Application Ref: H14-0532-26

Proposal: **Construction of BIO-LNG Refuelling Station**

Location: **Land off Bervor Close, Pinchbeck, Spalding, PE11 3ZN**

Deferral: LCC is not currently in a position to support the application and requests further assessment, supporting evidence, revisions and/or dialogue, as set out in the response.

Drawing Title: LNG DP STATION SITE/BLOCK AND LOCATION
PLANS
Scale: 1:250 and 1:2500
Date: MARCH 26
Drawn: DB
Checked: D

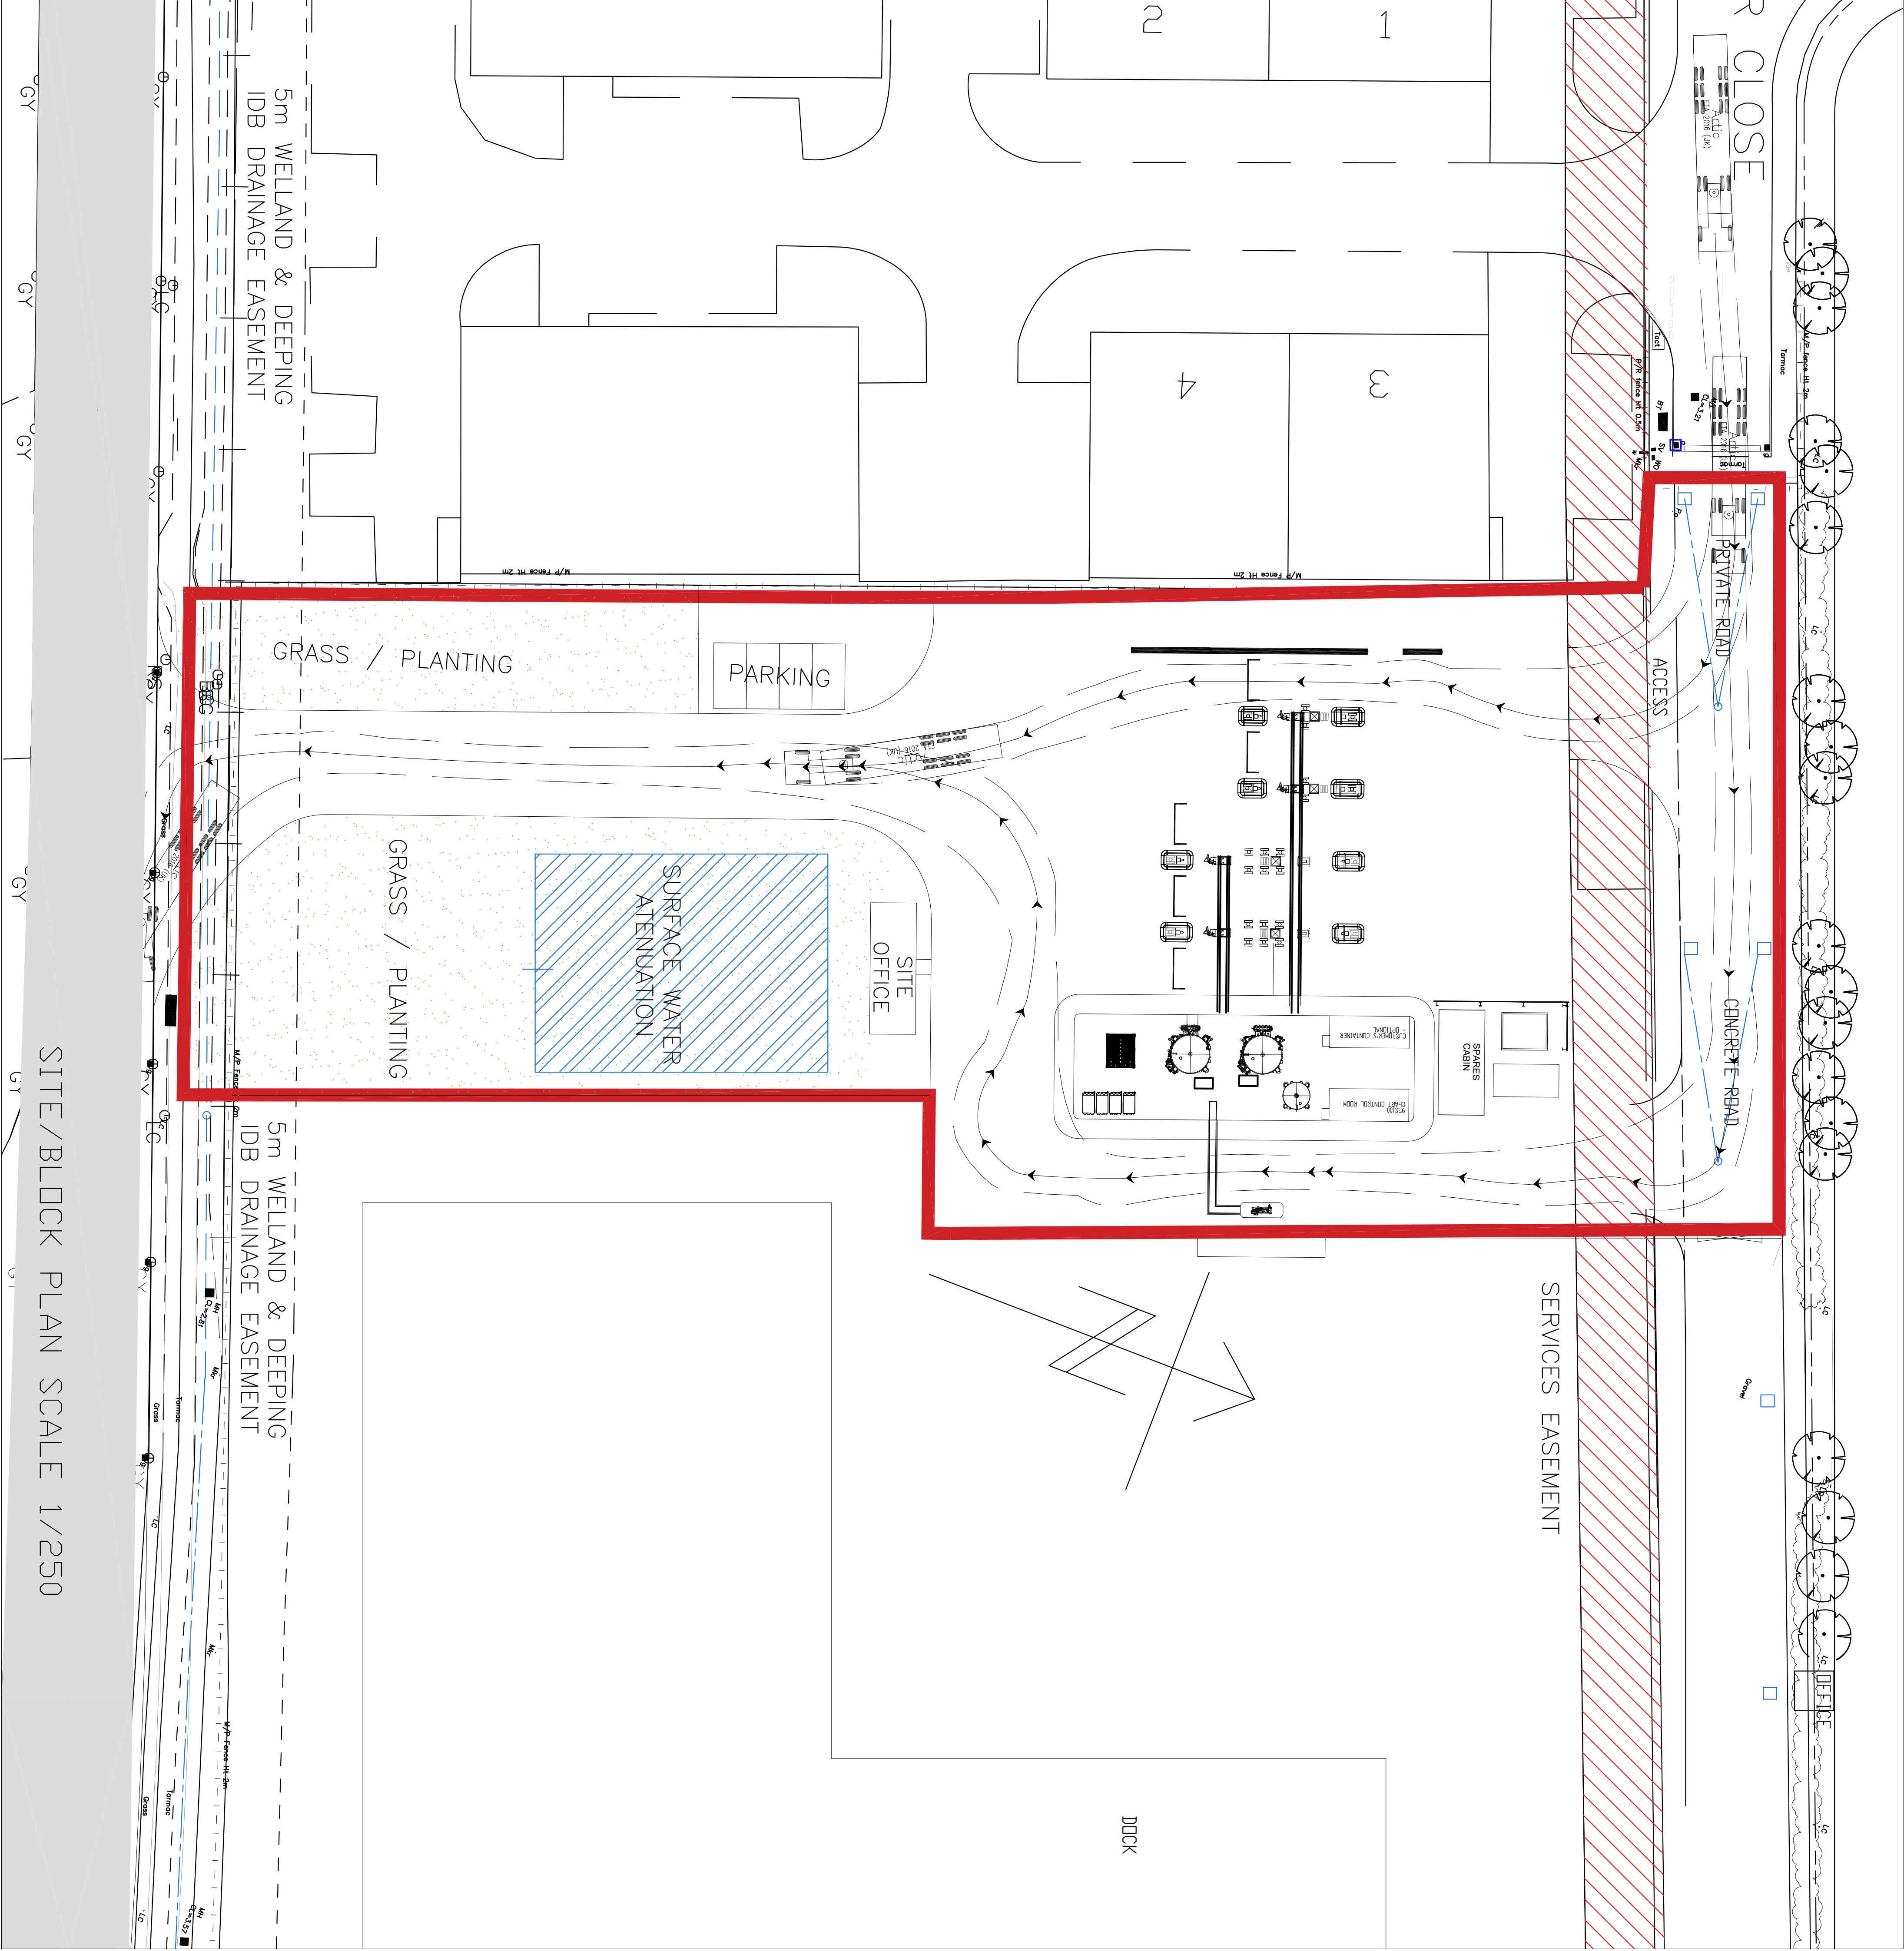
Both access should be constructed in accordance with LCC specification , this should be demonstrated on a plan.
